Your Ref: 100663135-002
Our Ref: 24/00588/LBC

Date 22nd March 2024

Application No: 24/00588/LBC
Proposal: Listed building consent for internal alterations to include conversion of bar to store and installation of internal doors and chimney vent, replacement of ceiling, radiators, and removal of cabinet with associated plasterwork, painting and refurbishment works
Address: St Andrews Town Hall Queens Gardens St Andrews Fife KY16 9TA

STORE DOORS ELEVATION - AS PROPOSED
1 : 20

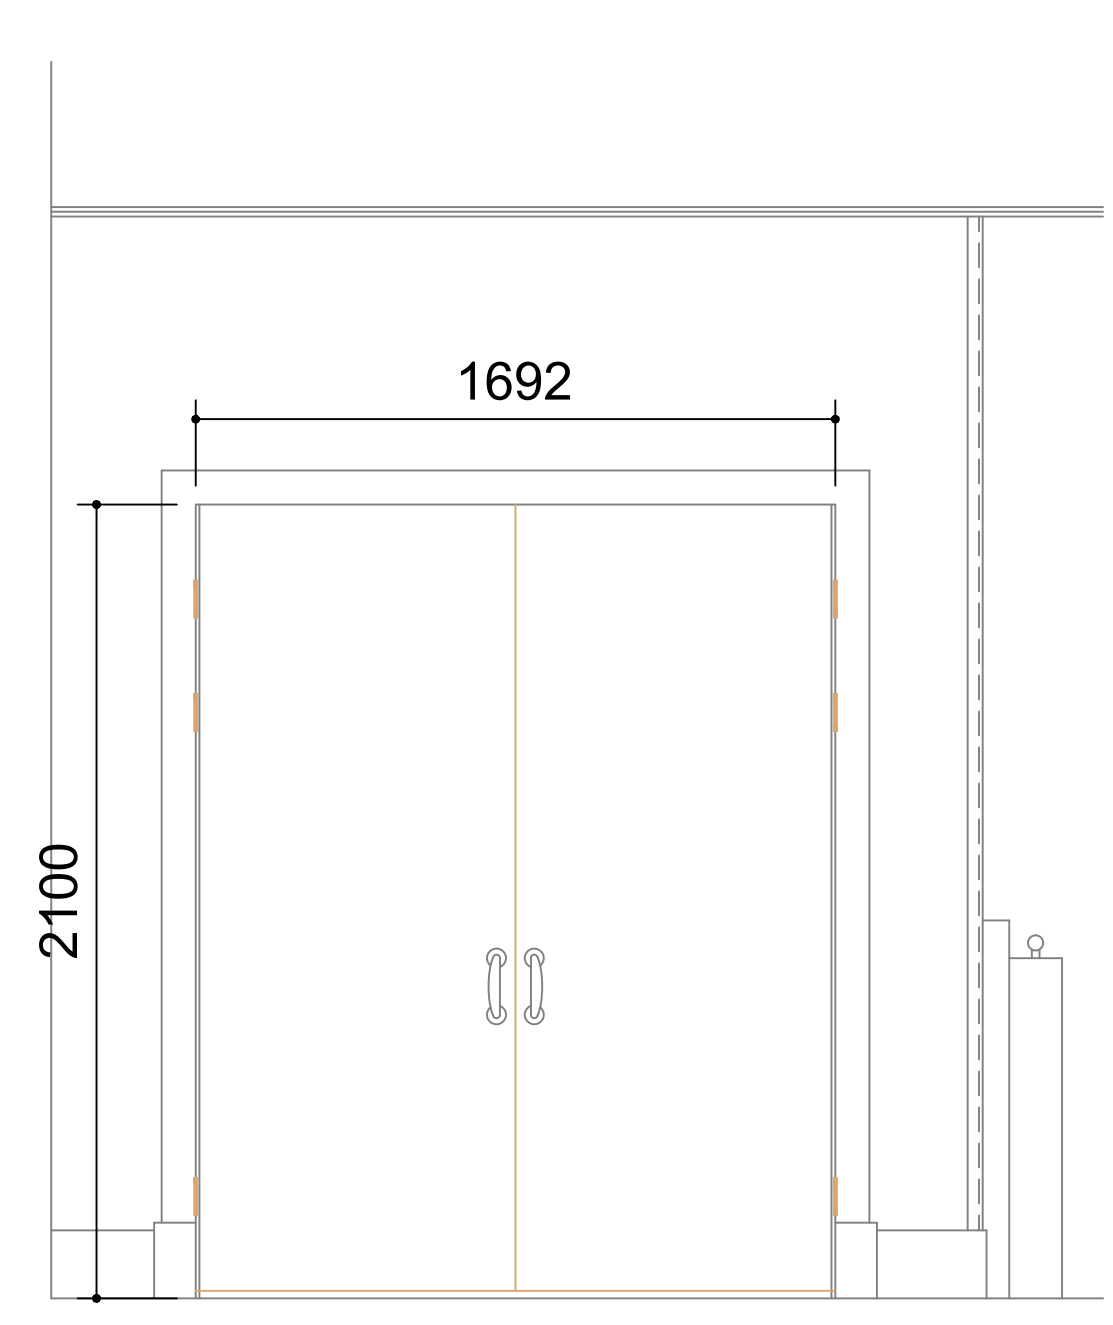
1. Please provide a 1:20 detail of the proposed internal doors to the new store area. This should include details of the material and colour finish as well as any proposed door surround detail and supporting brochures for the proposed ironmongery.

Drawing Title : CHAMBERS ELEVATIONS - AS EXISTING & PROPOSED

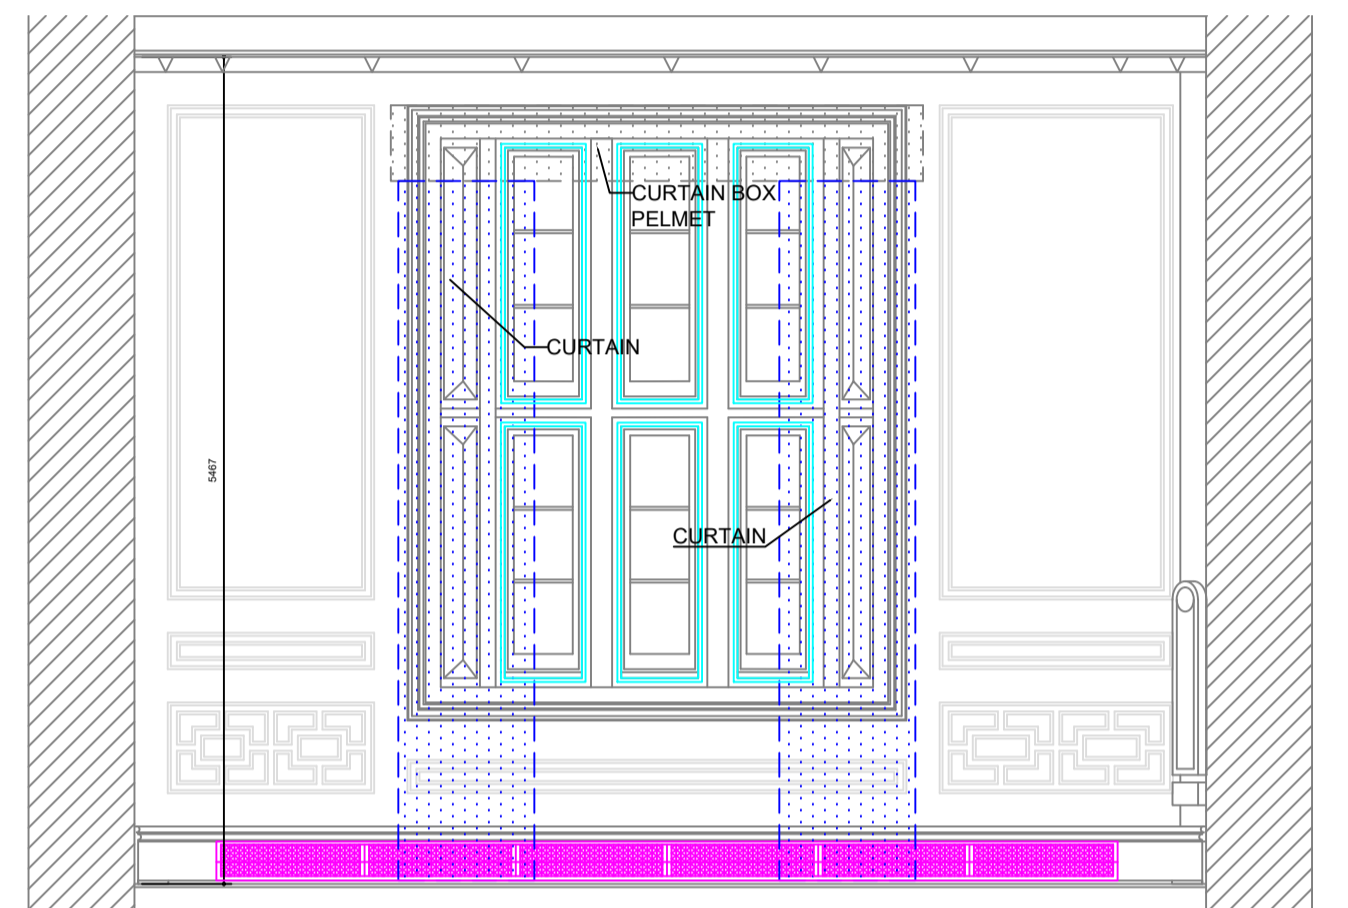
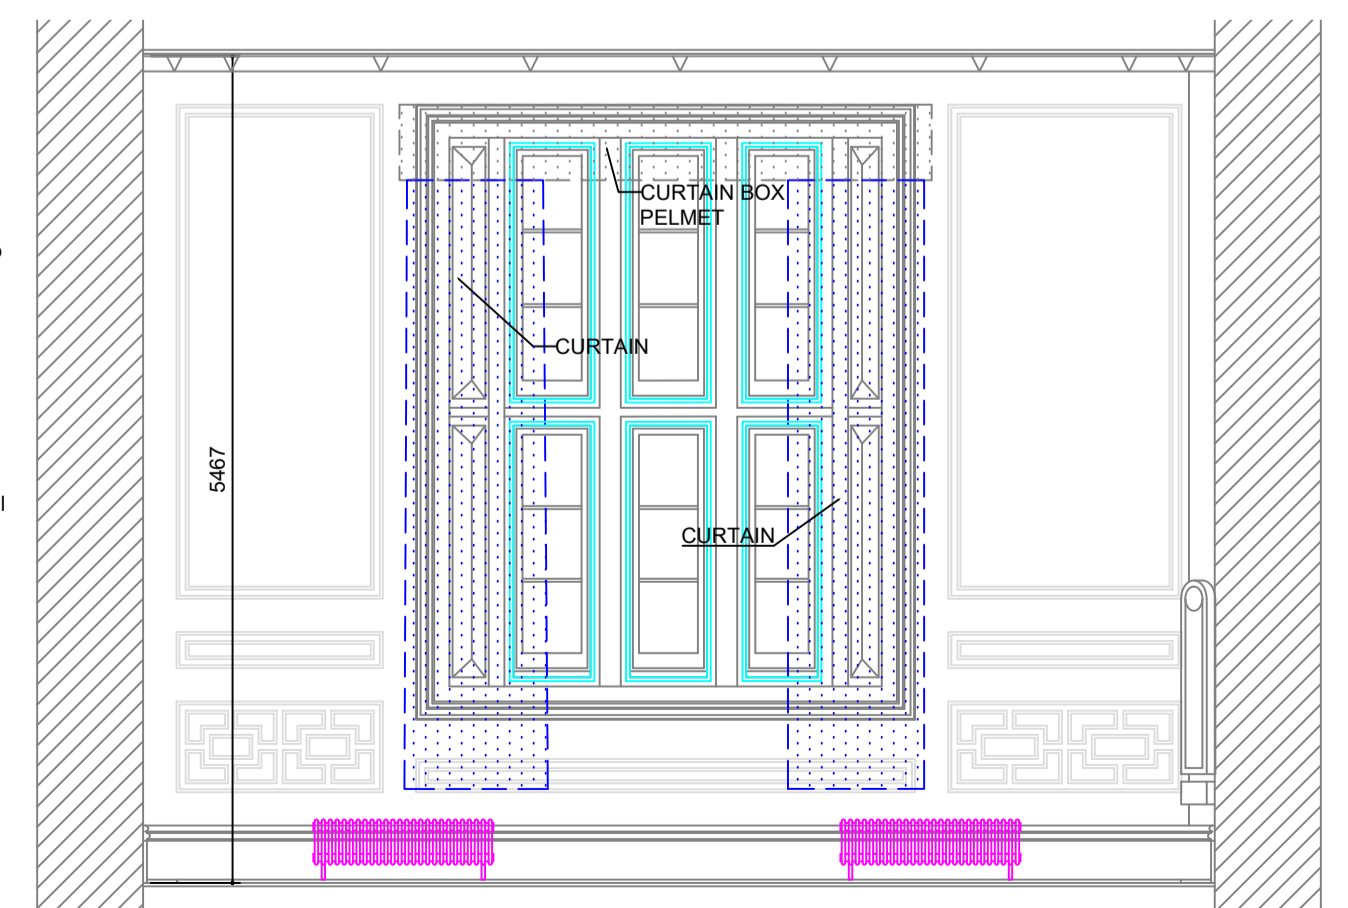
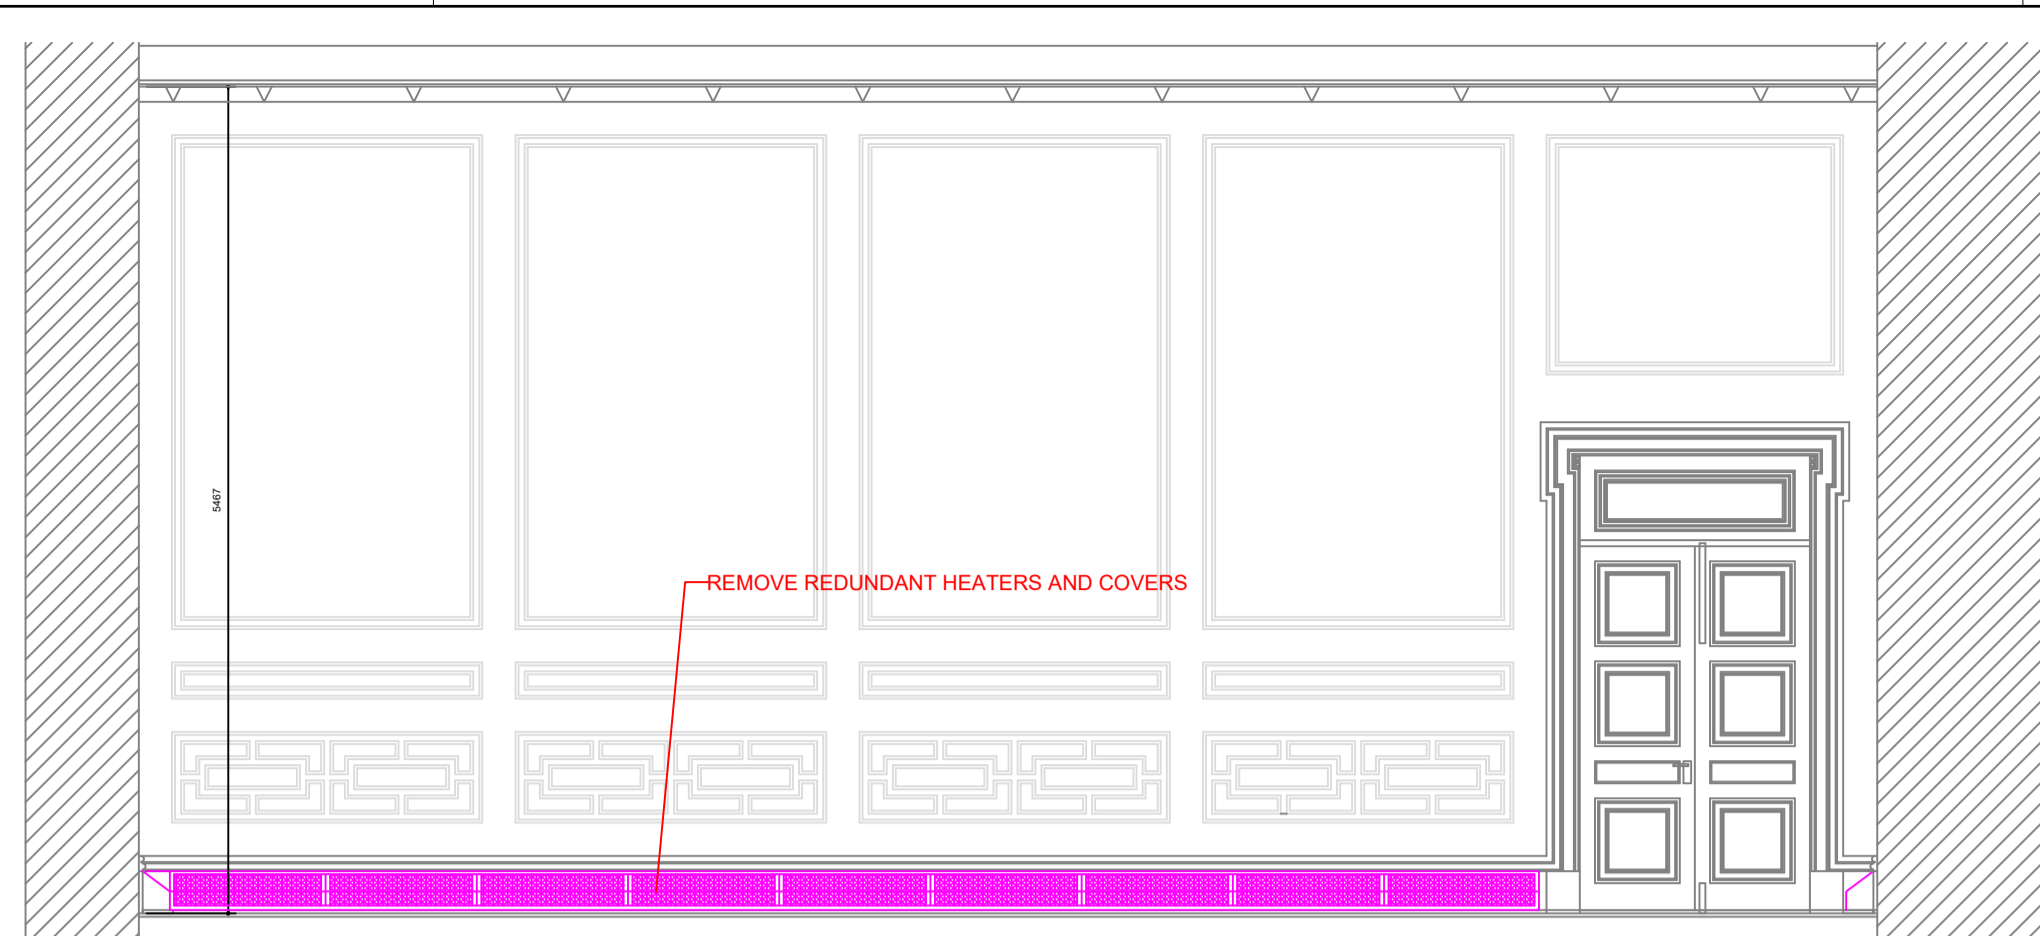
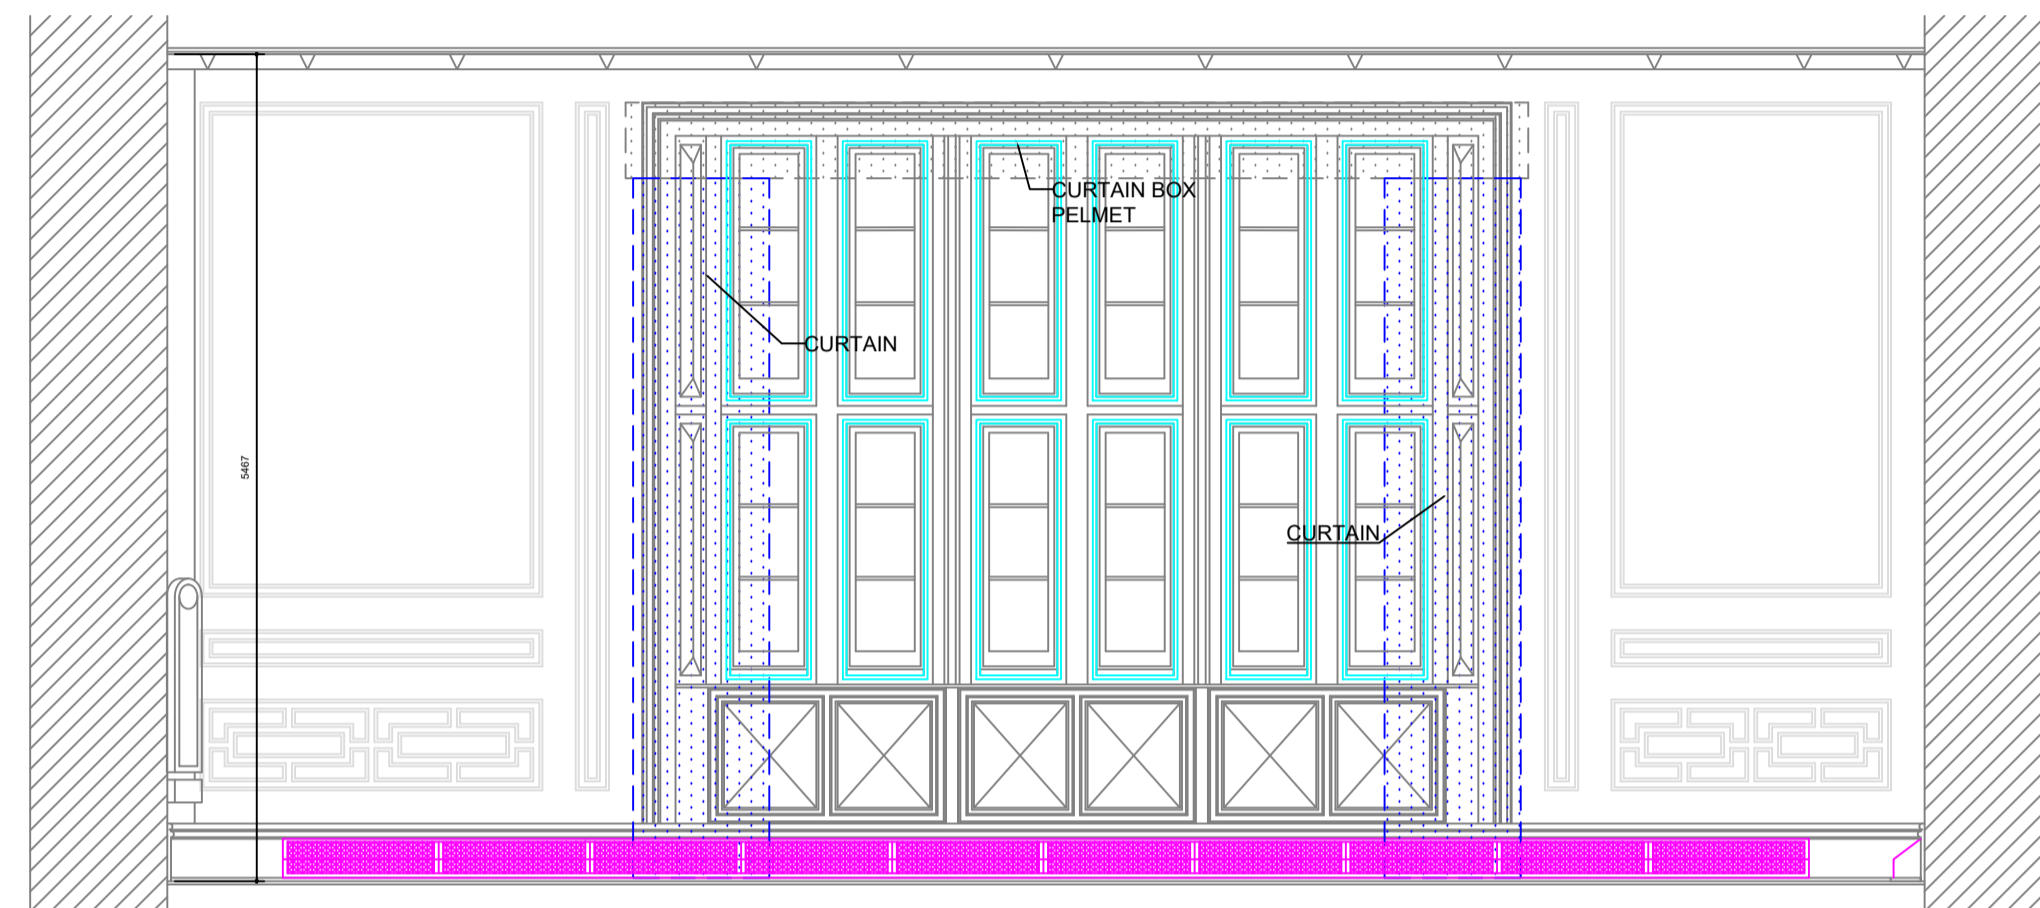
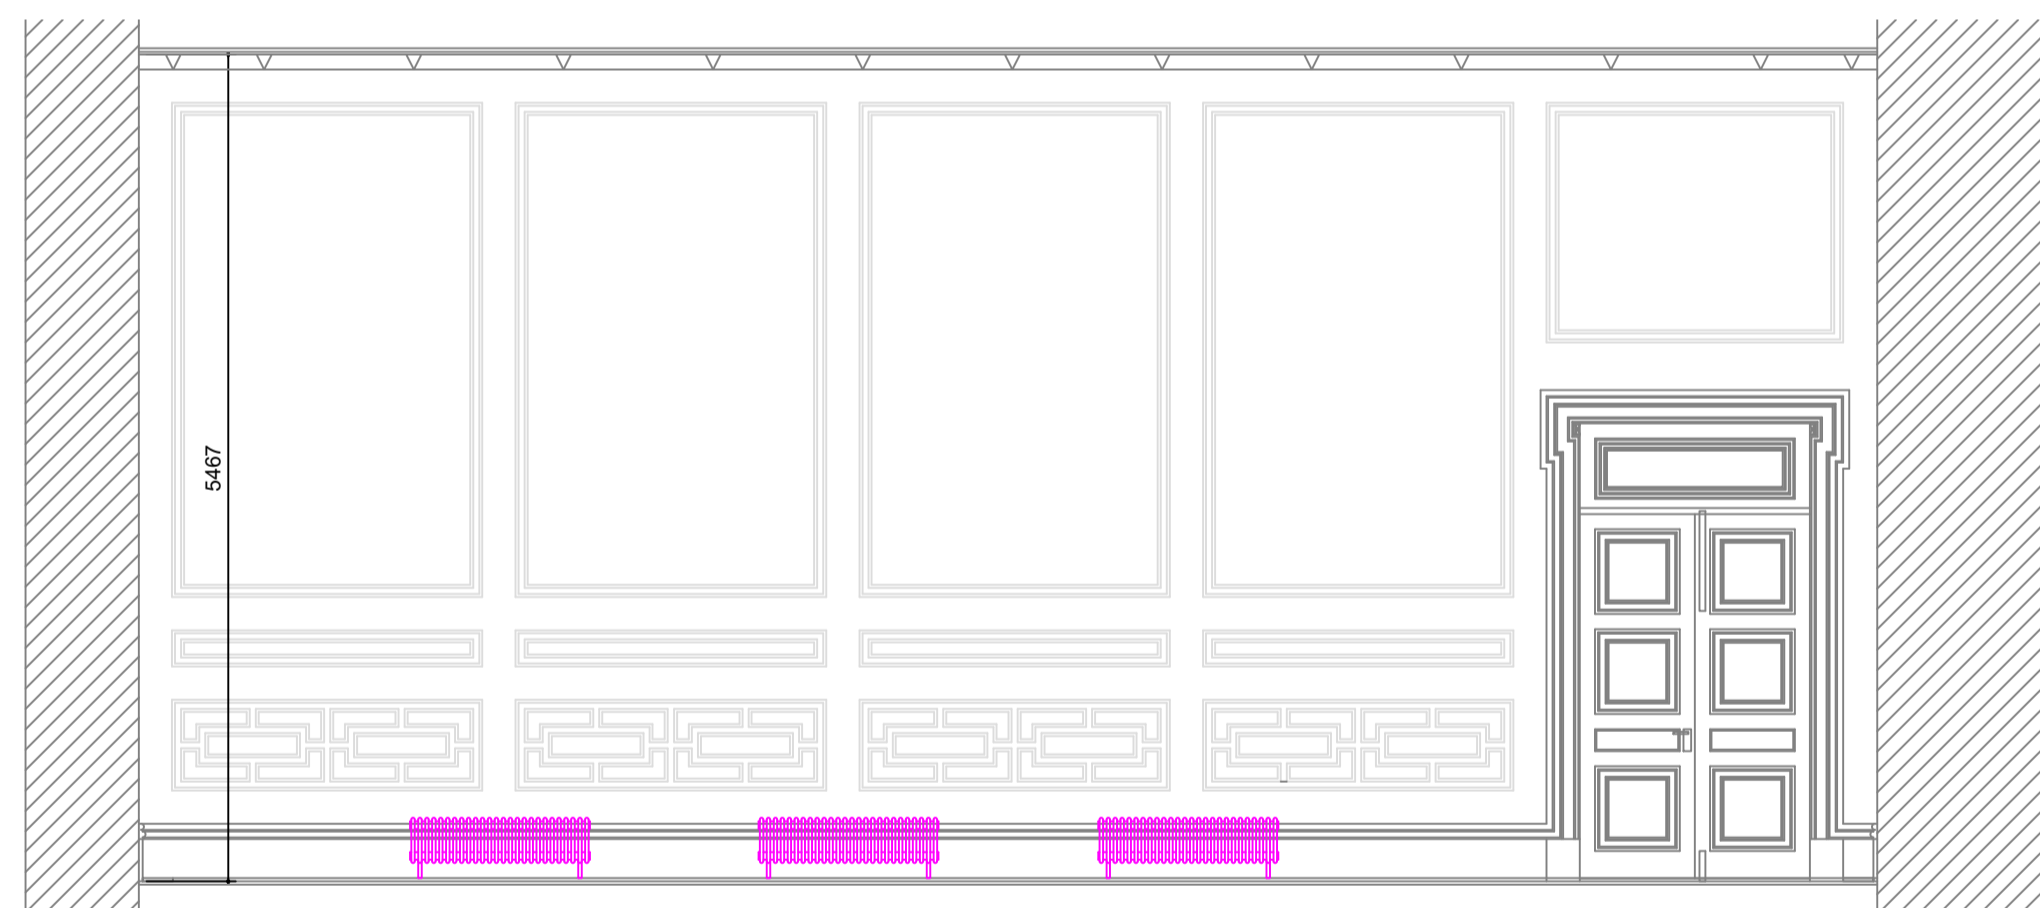
2. Please provide existing internal elevations to compare against the proposed elevations as submitted. For clarity this is to understand the differences between the old and new radiators and given that the radiator detail is not to scale.
